31/10/2019

**Australian Technology Park Building 2 Modifications (SSD-7317-Mod-17)  
Request for Additional Information**

Elevations - South & East

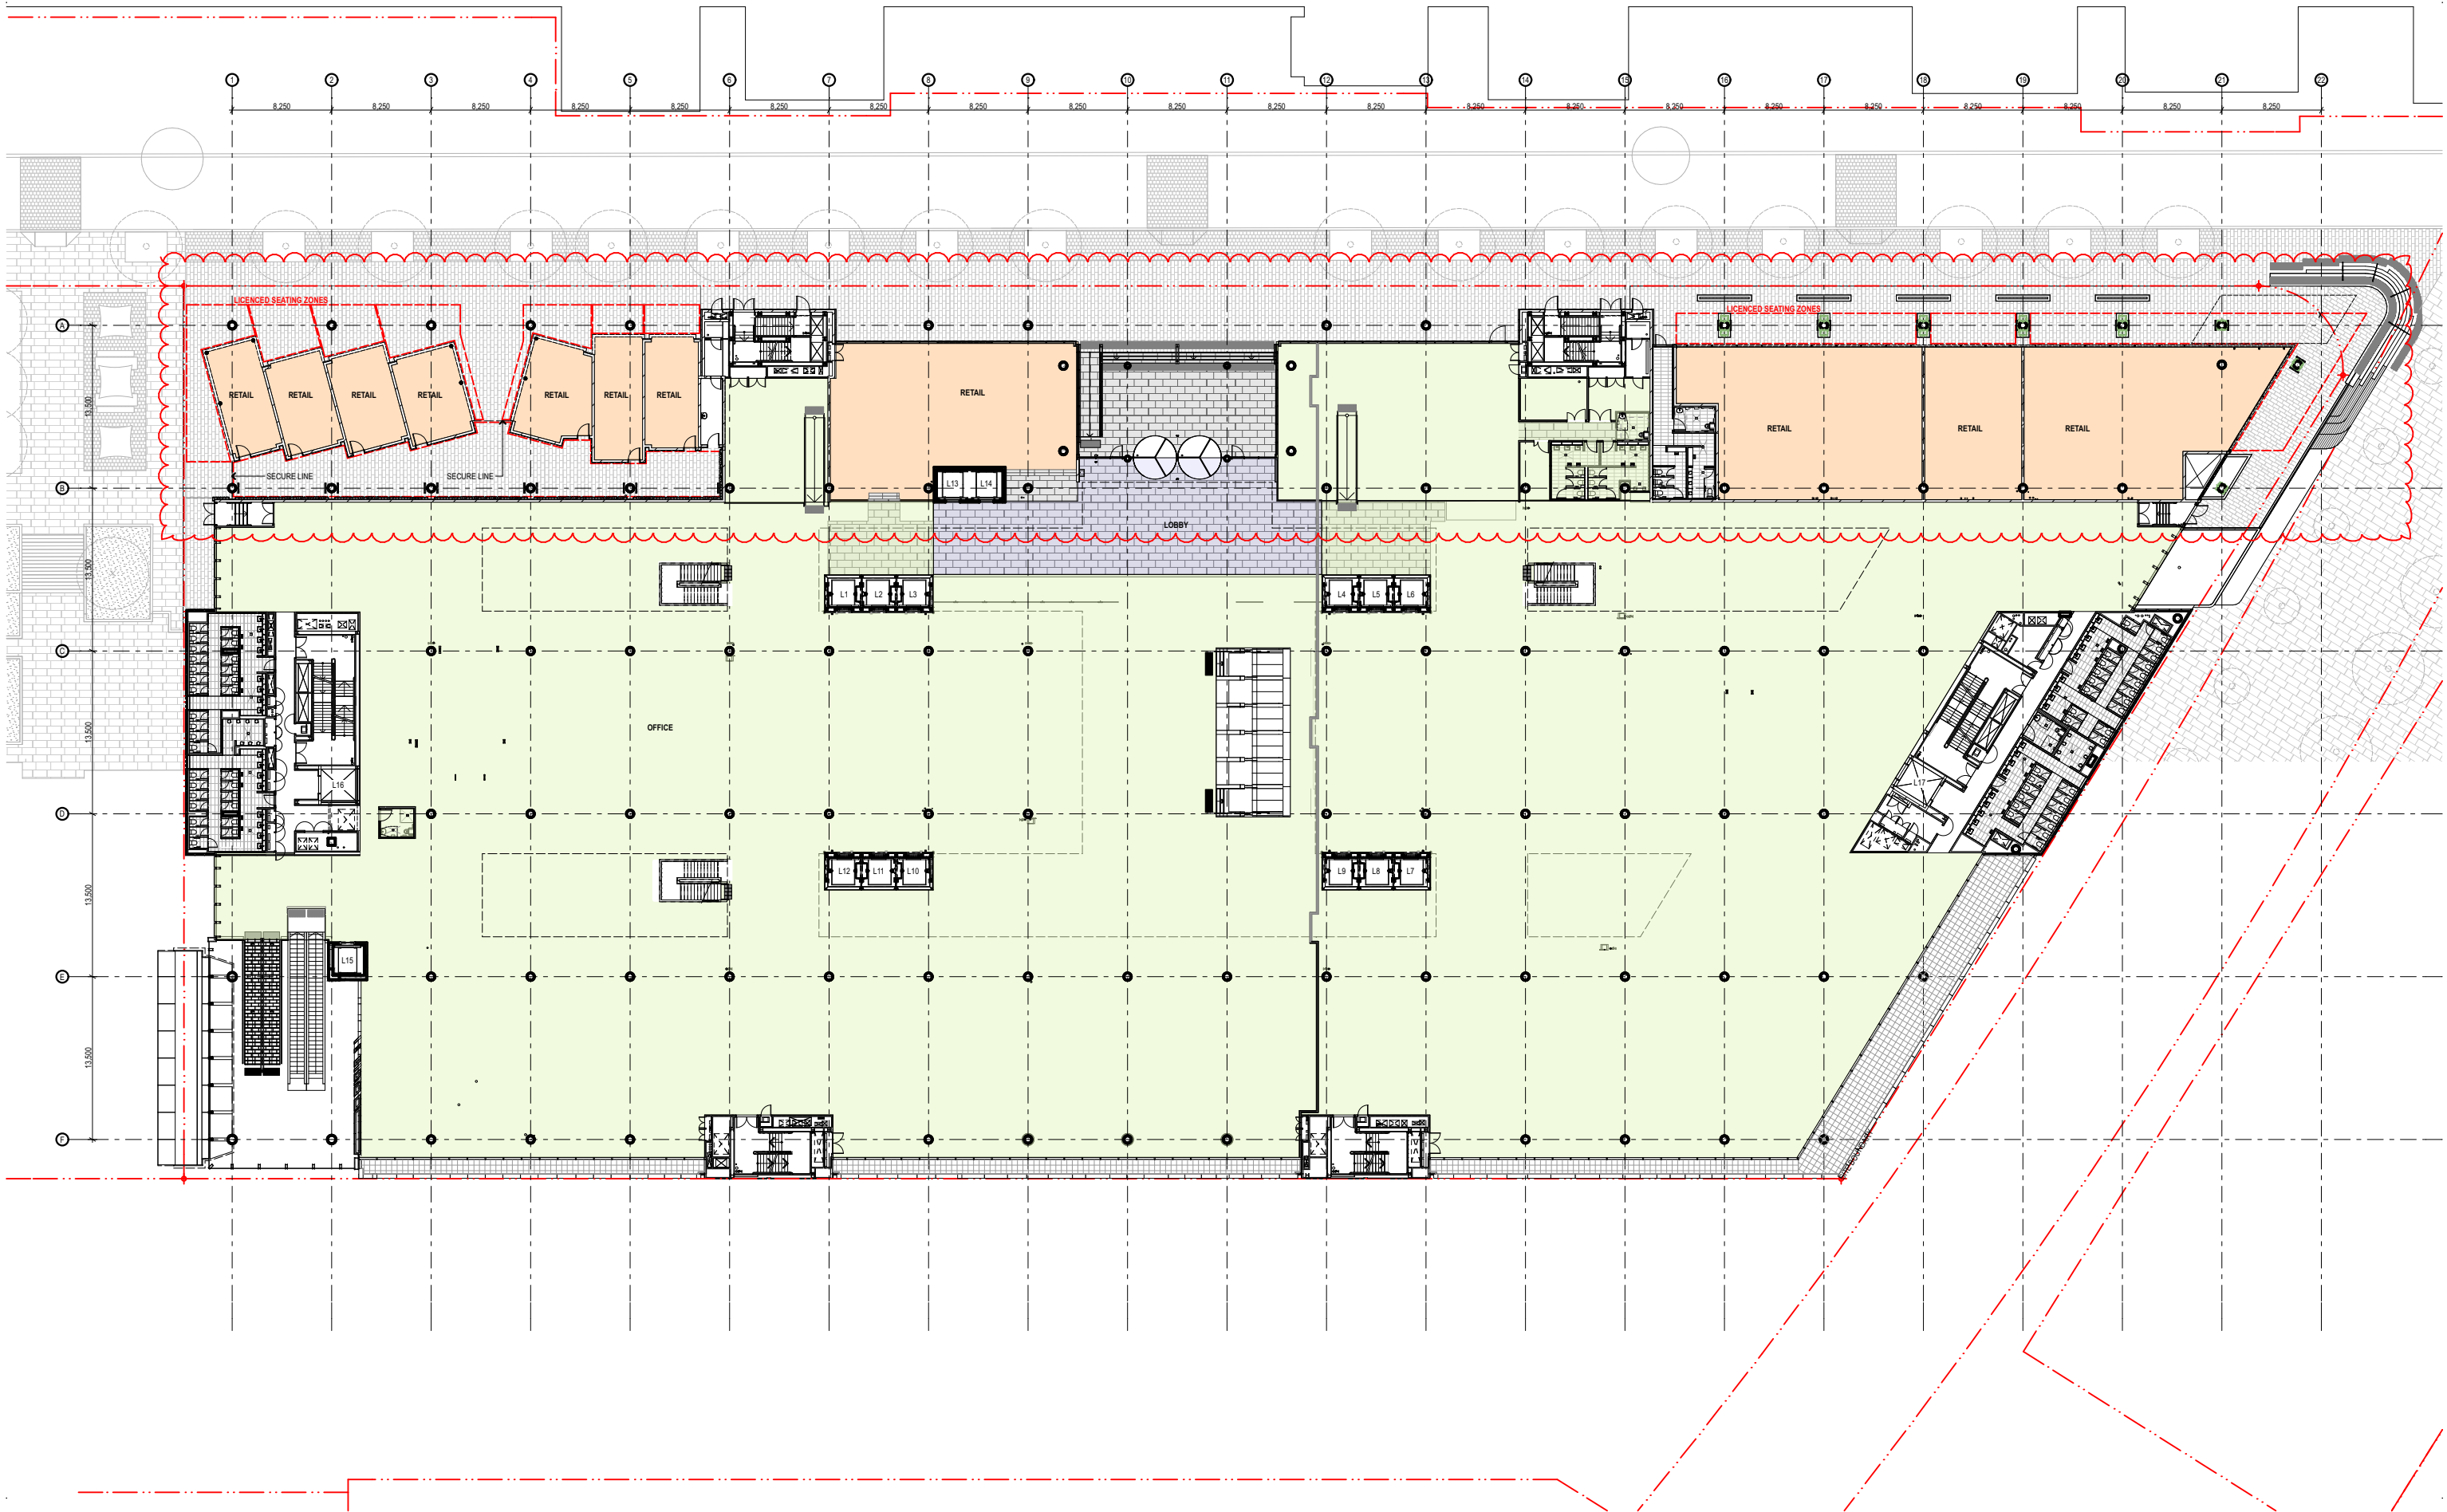
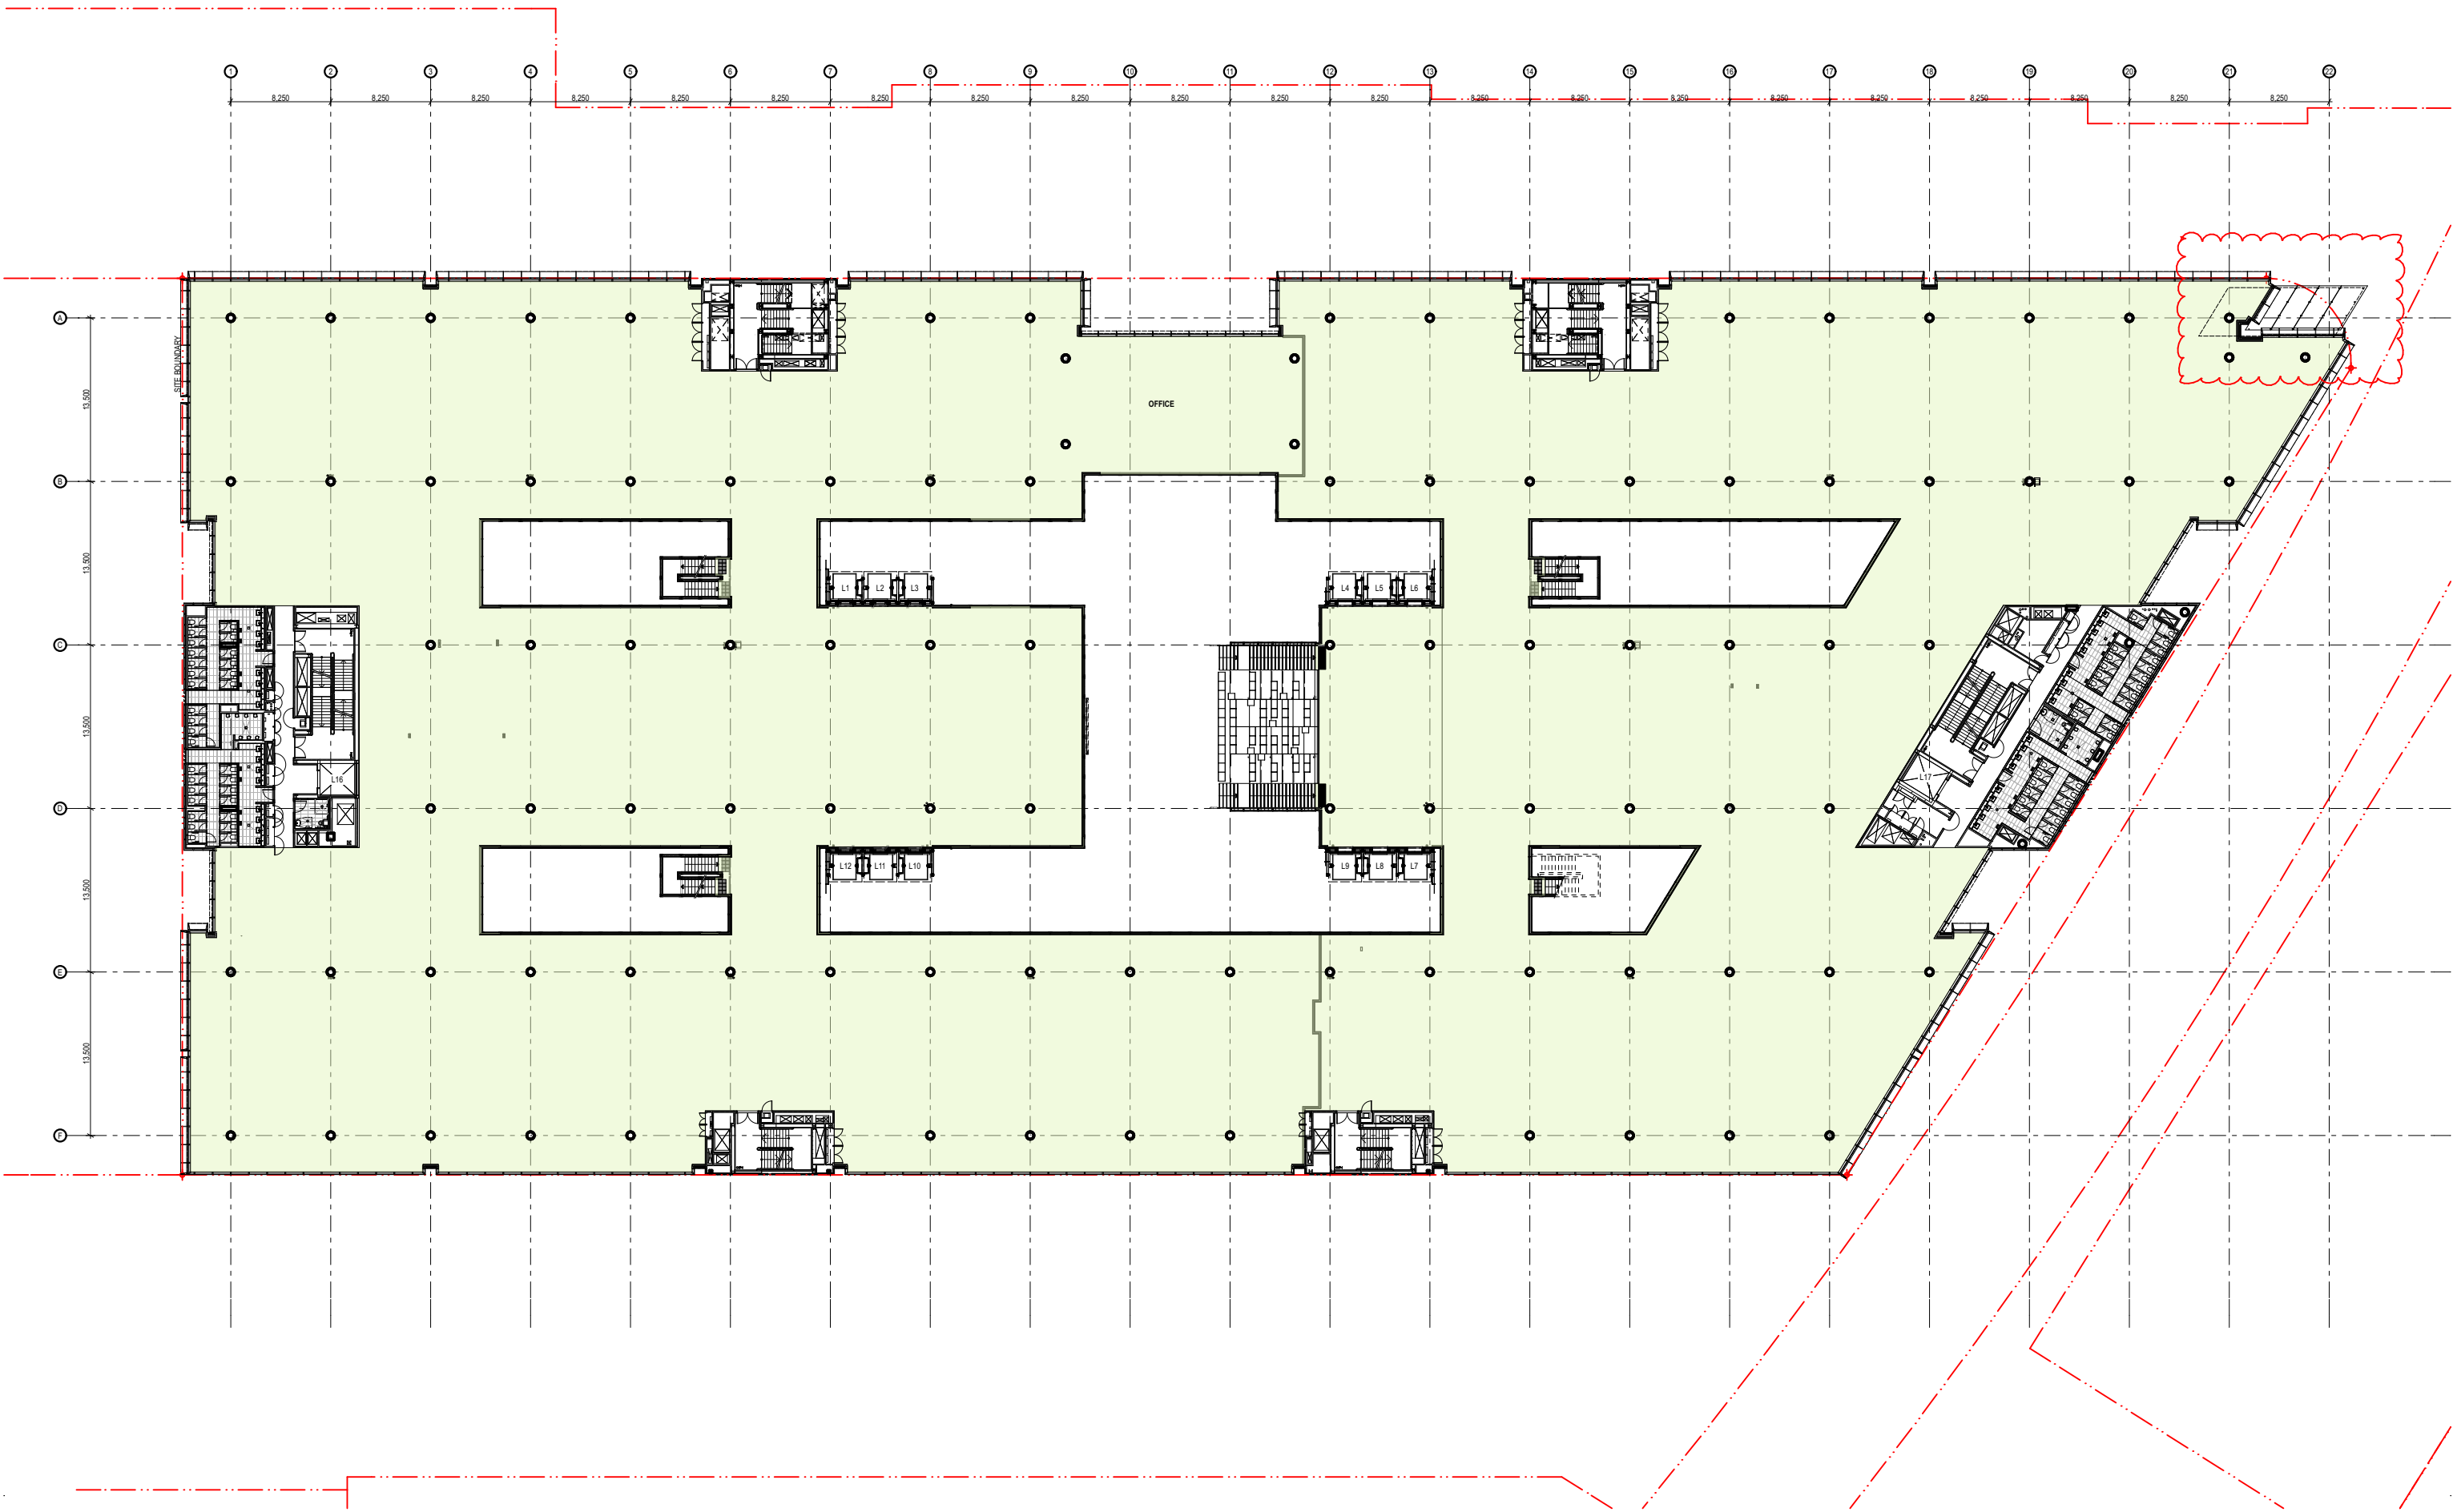
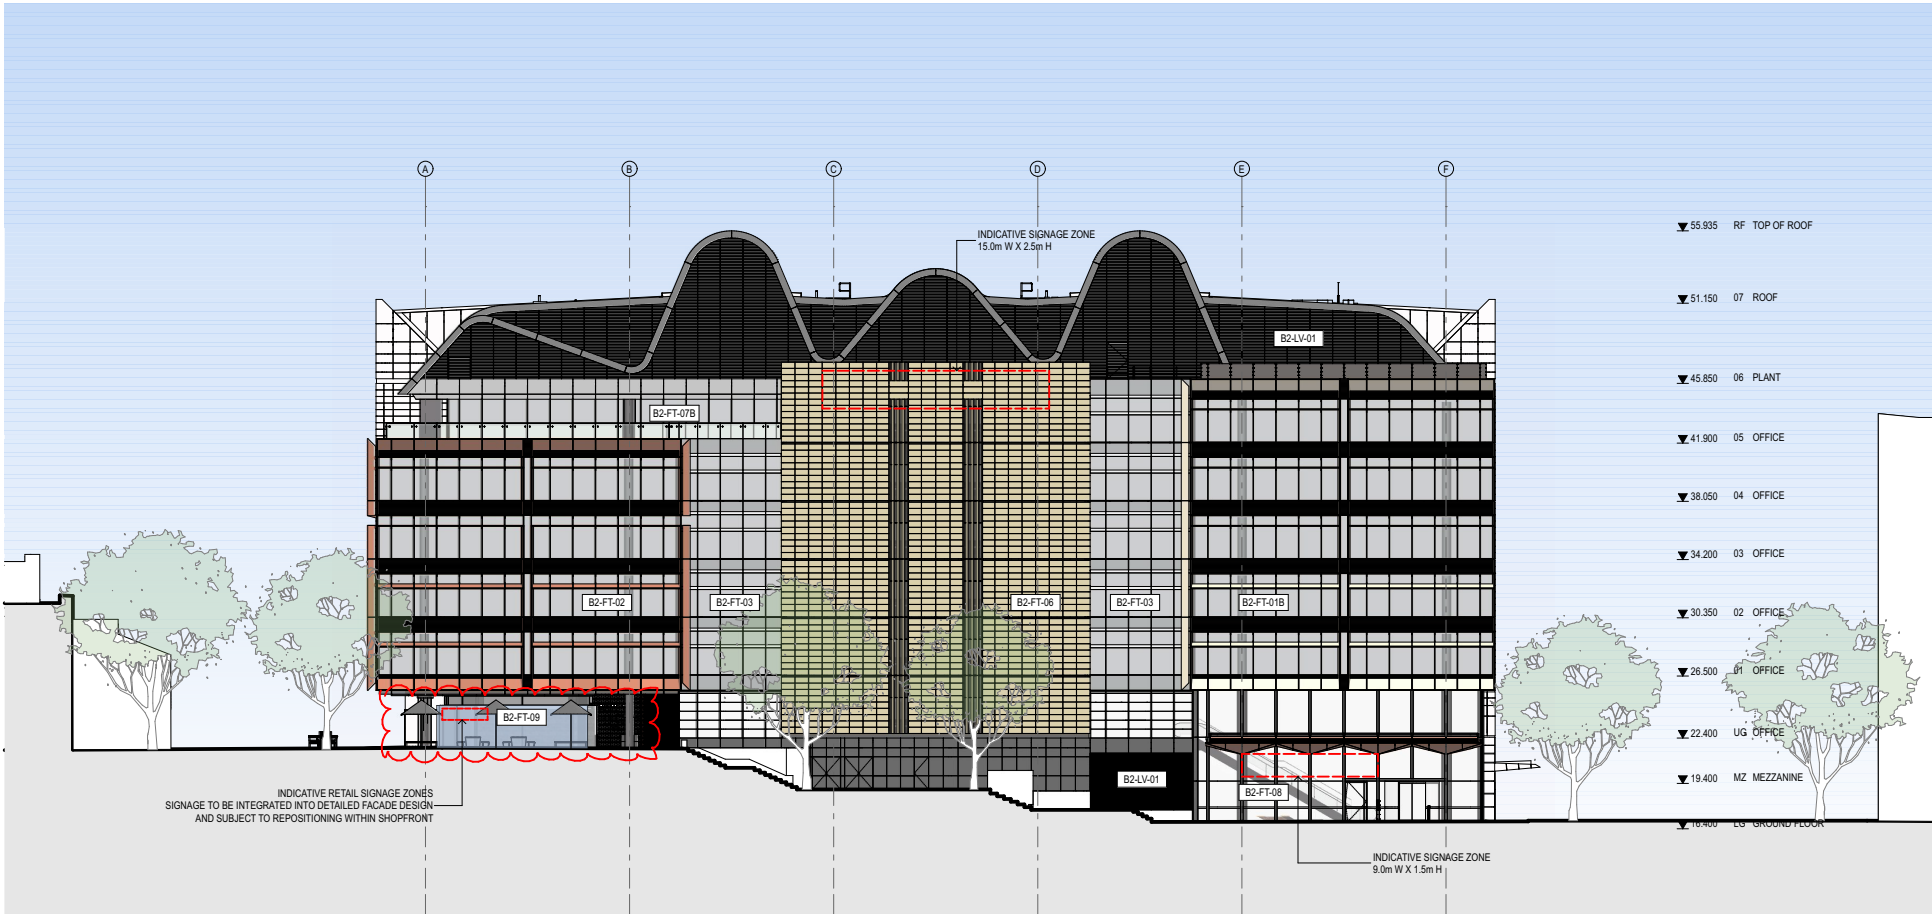
- confirmation that all landowner's consents have been provided
- further details responding to Council's concerns regarding the level of detail within the Retail Design Guide on acceptable shopfront designs
- clarification on the number of signage zones proposed for Building 2, noting that the modification report states a maximum of 23 signage zones are proposed but not shown on the plans
- clarification on the intended function of the proposed rooms near the eastern end of both the western and eastern retail zones.
